Barangaroo Central Waterfront Promenade and Interim Public Domain Works Summary of Submissions

Barangaroo Headland Park Main Works (Marine) Tender Design Navigational Aids Drawings

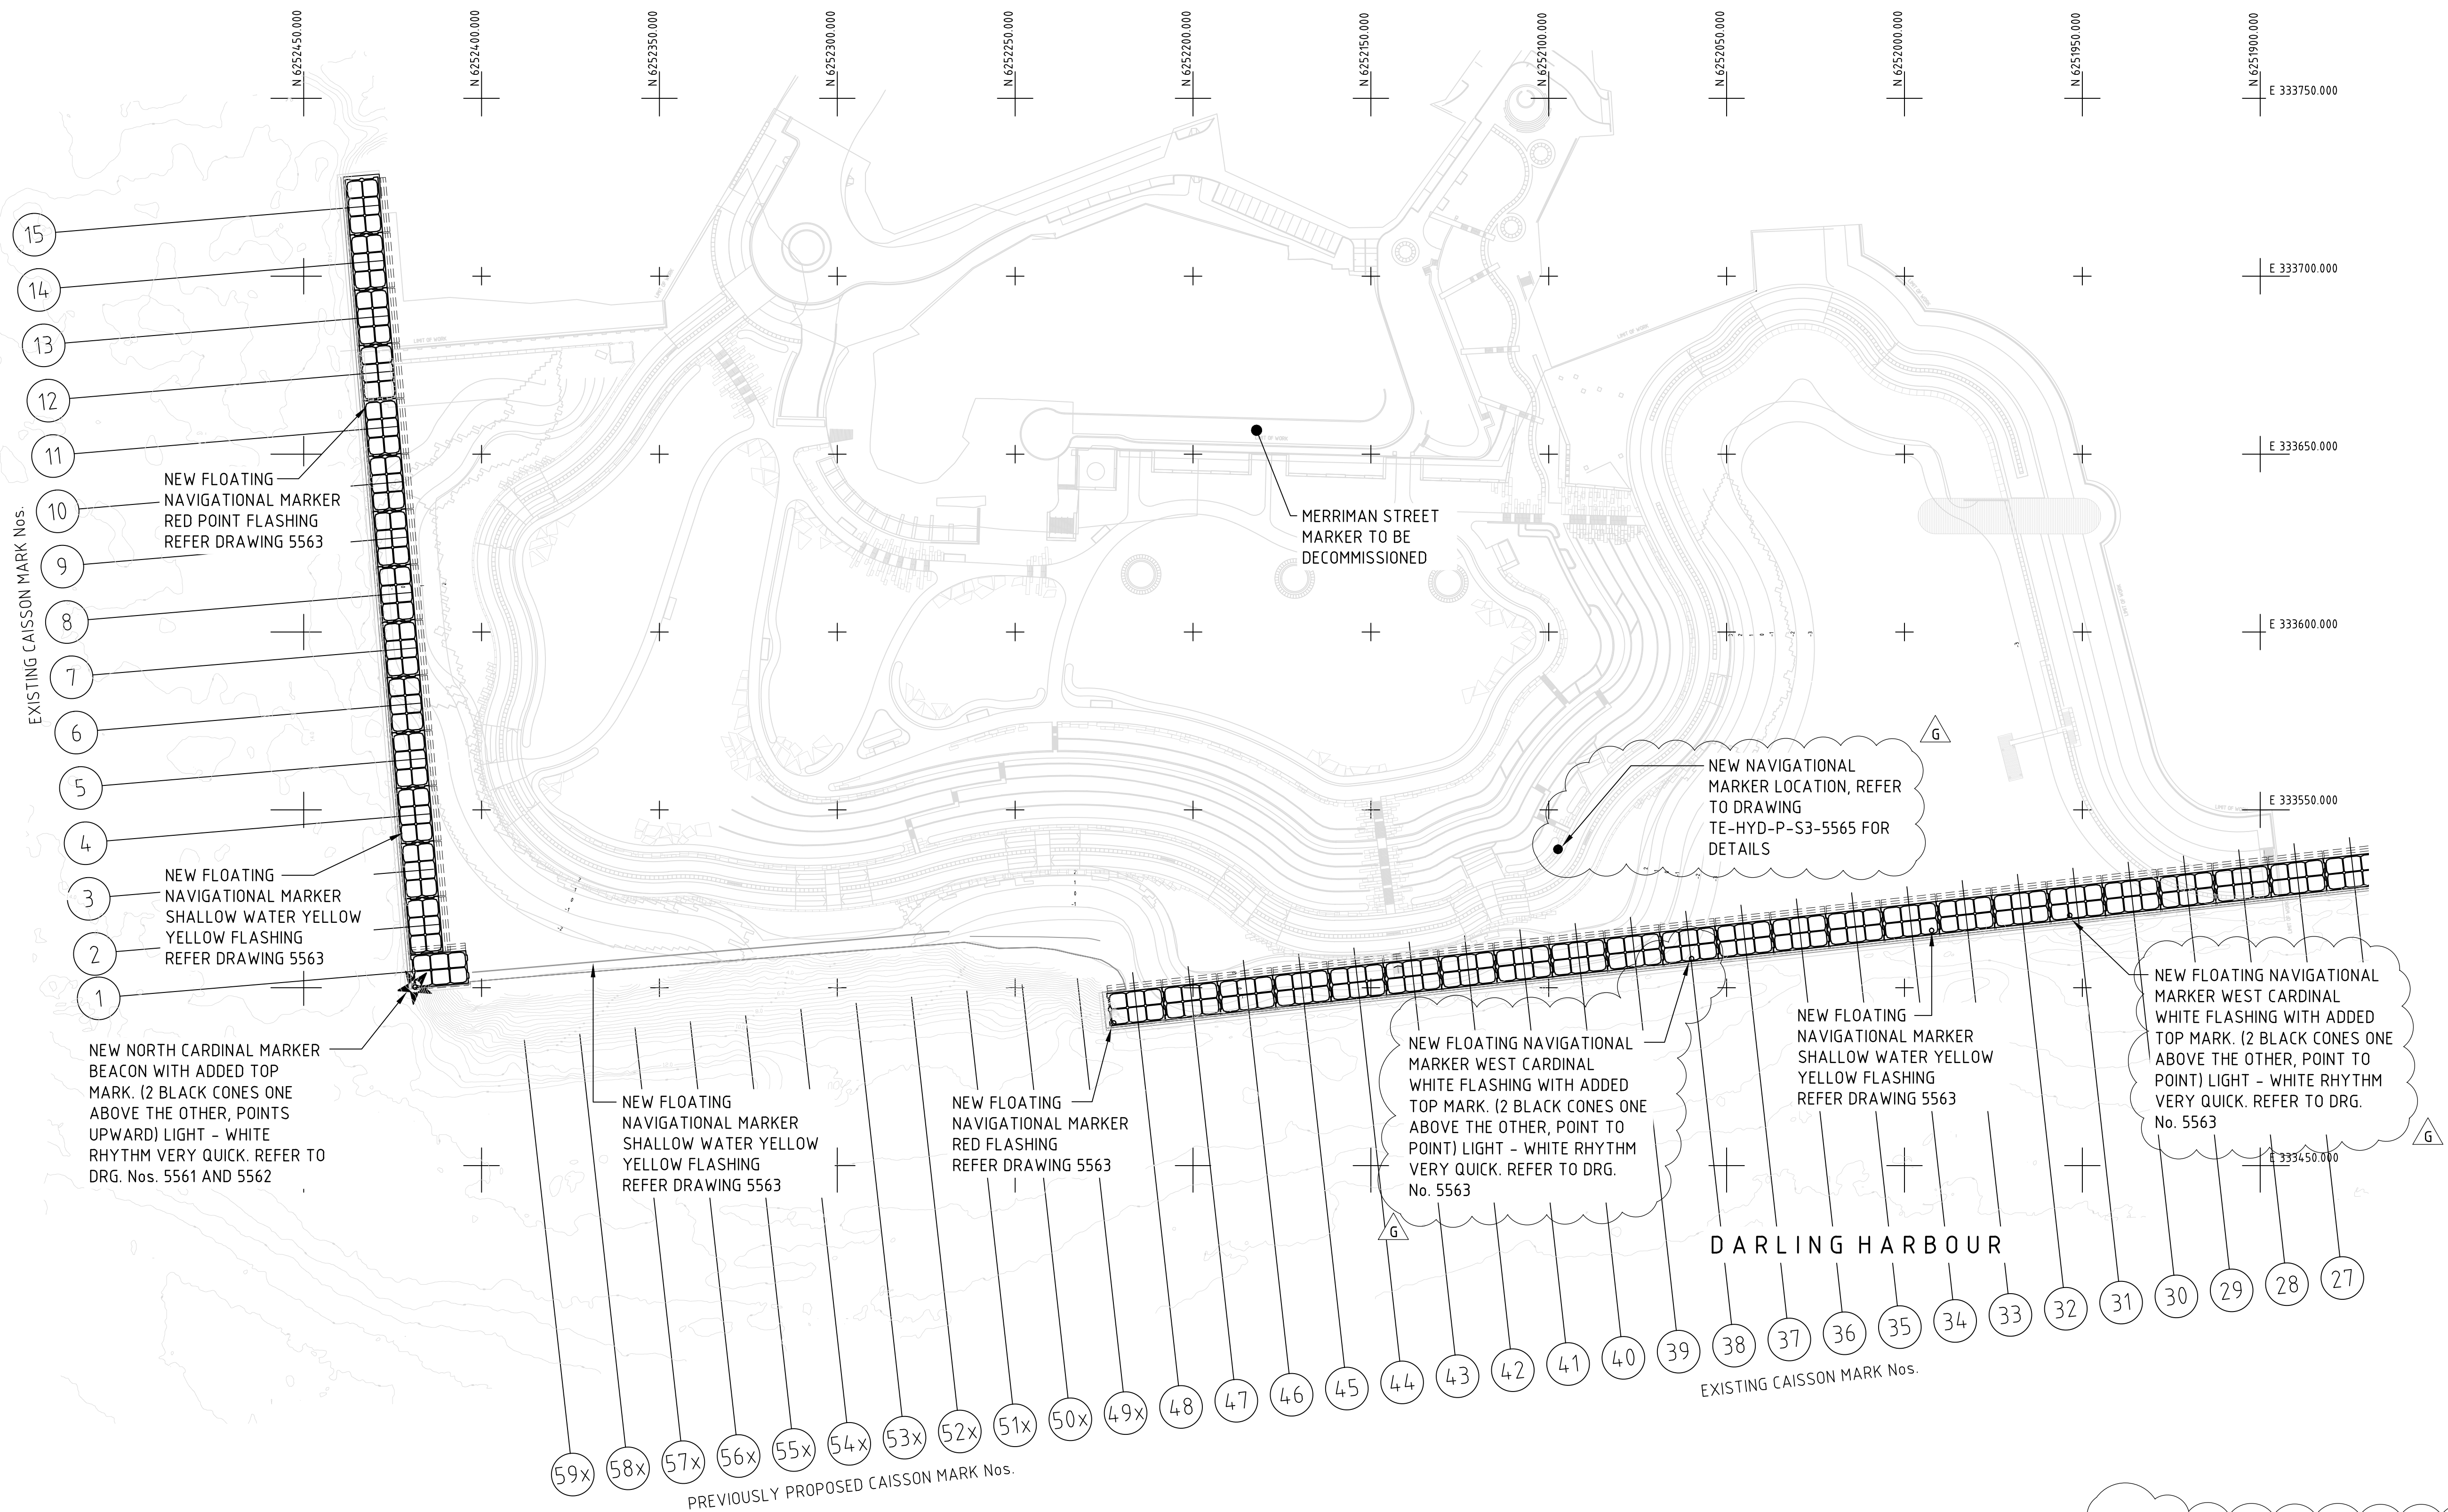
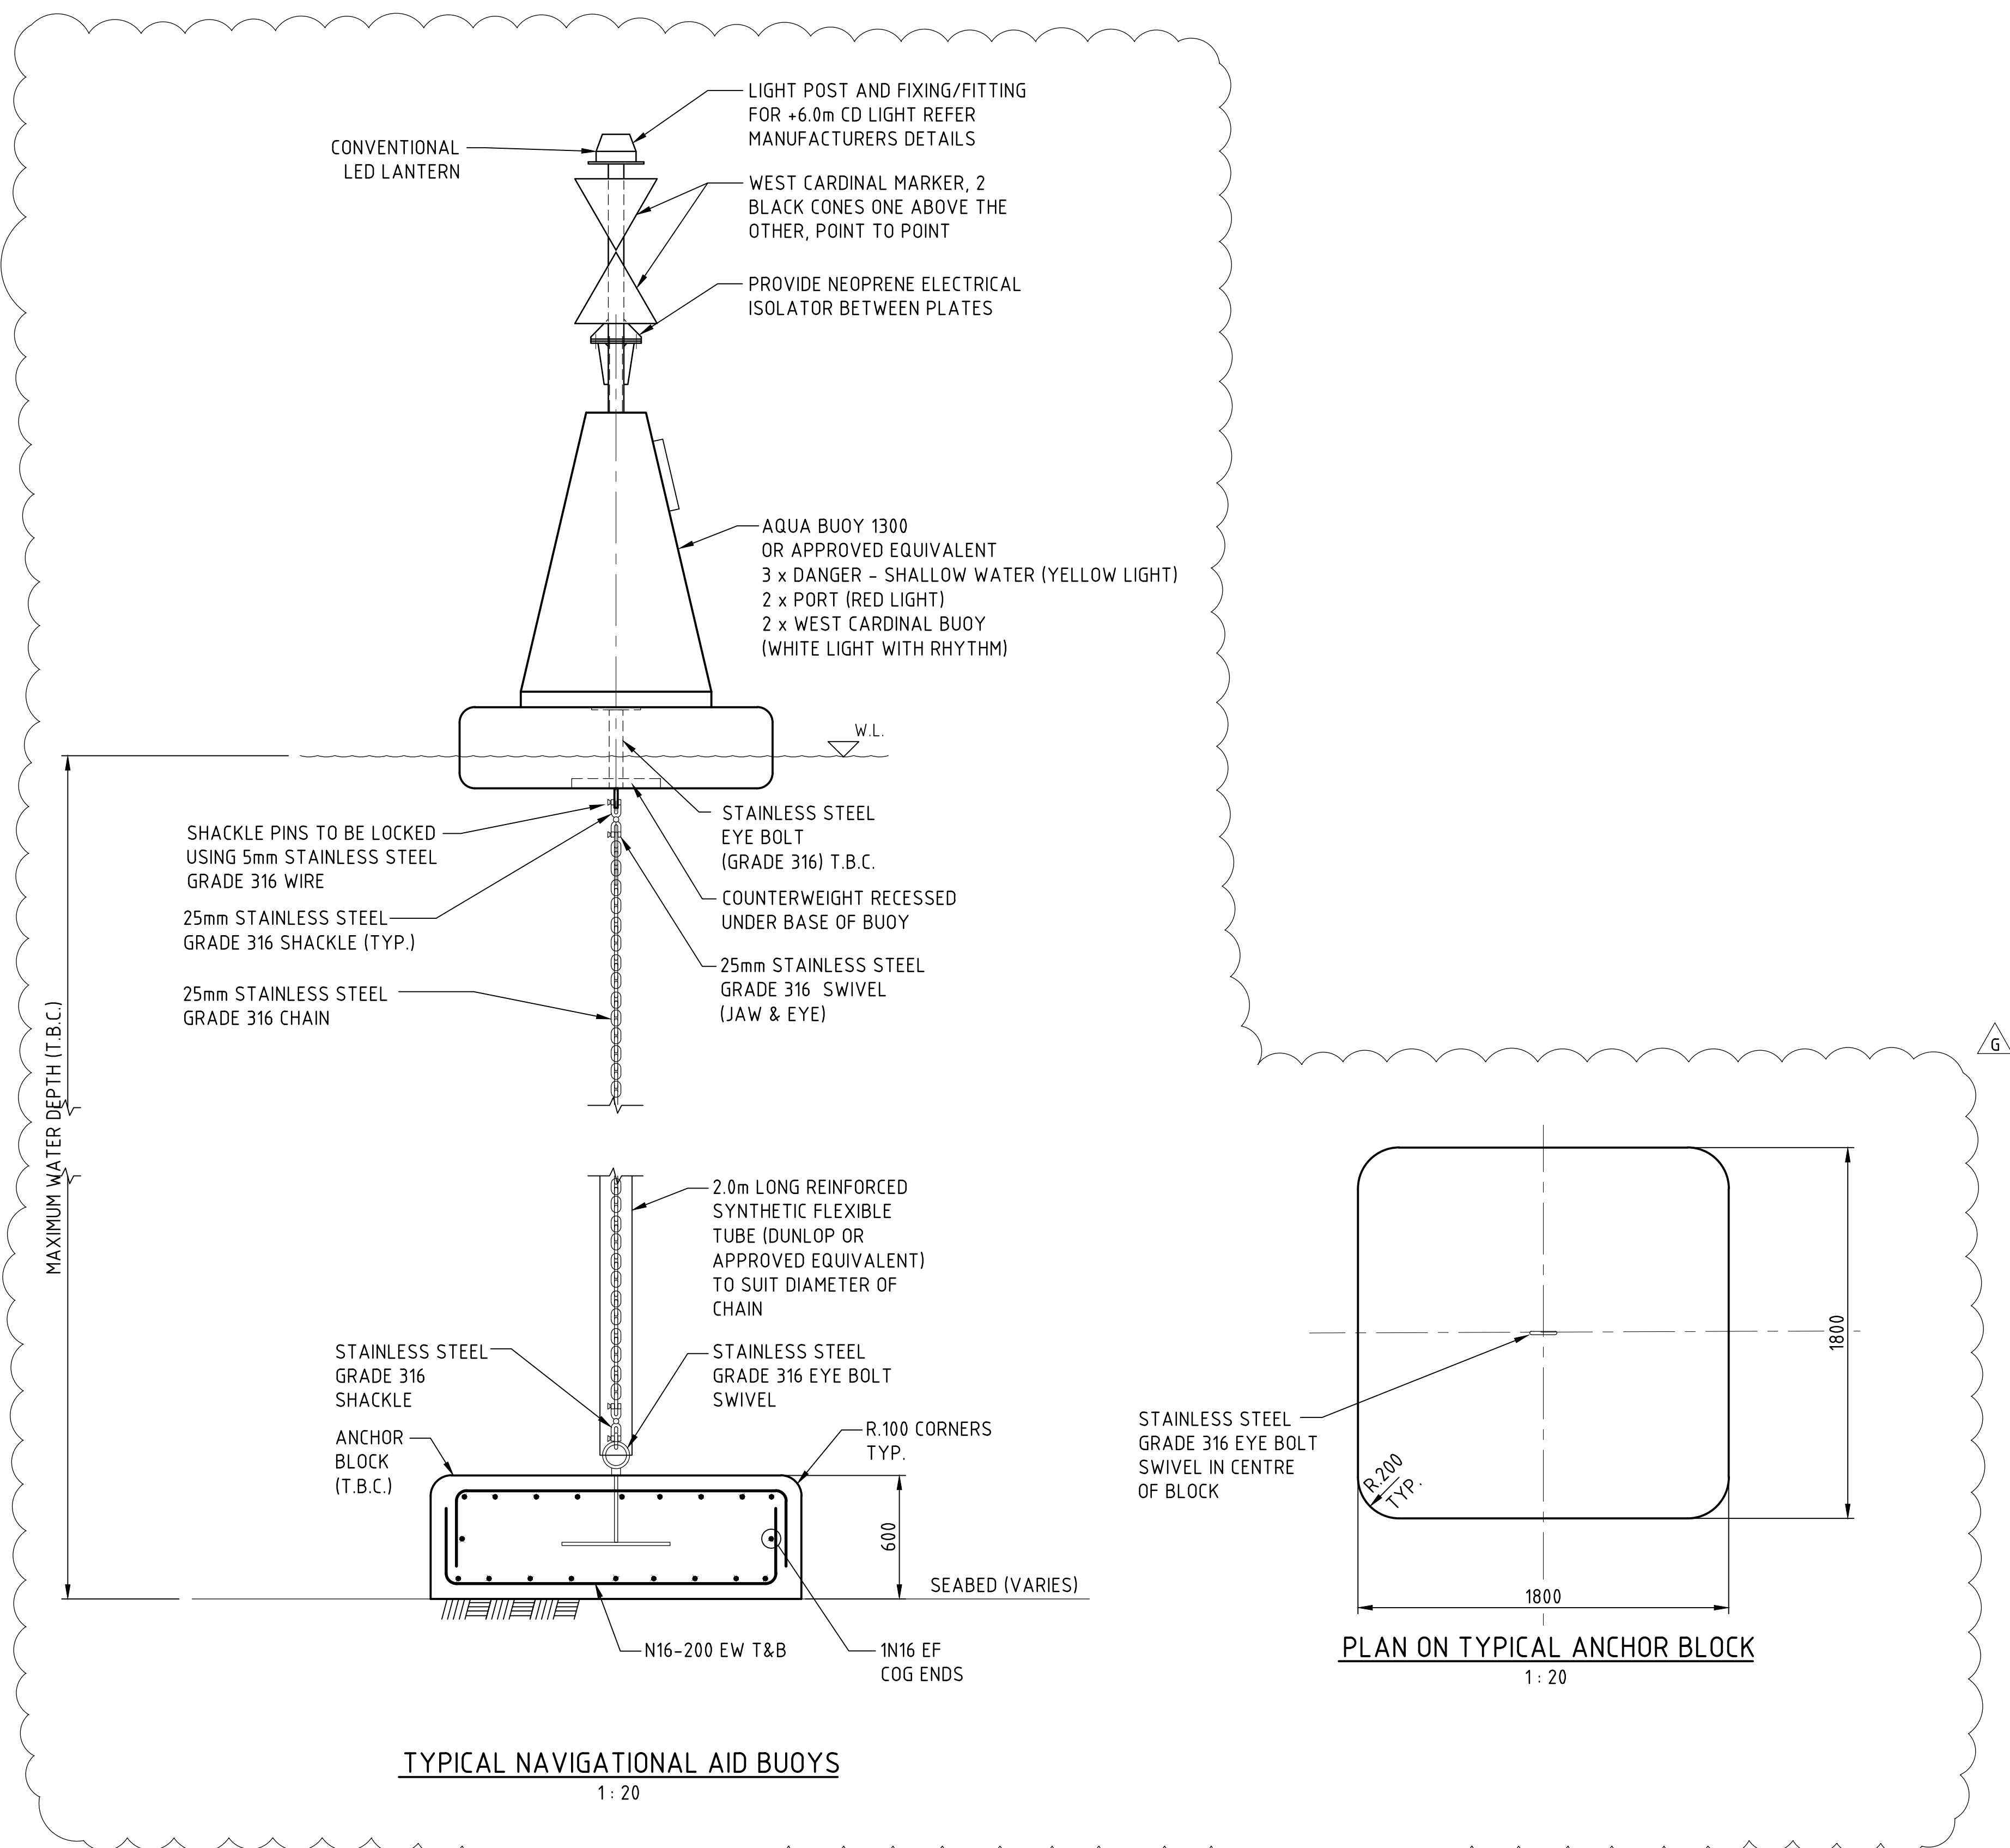
Submission from	Issues Raised	Response
Sydney Ports Corporation	<p>Text on Appendix 13 (p10) regarding navigation aids is inconsistent with drawing provided in Appendix B. It is understood that Appendix B is correct but confirmation is required.</p> <p>The minimum RL for the northern cove of -4m may be reduced to a RL of -3m. Should RLs change, the BDA should undertake further investigations regarding suitable depths for water taxis to ensure safe navigation.</p> <p>Further consultation and discussions will be required with Sydney Ports and the Harbour Master prior to berthing large vessels (ie over 30m in length) along the quay.</p> <p>Harbour Master is also responsible for issuing warning regarding construction zones in addition to RMS (Appendix 13, p11).</p>	<p>Refer section 2.6 of the report and Hyder Consulting advice at Appendix 6.</p> <p>Appendix 13 of EIS has been amended to address relevant issues as outlined at Appendix 6.</p>
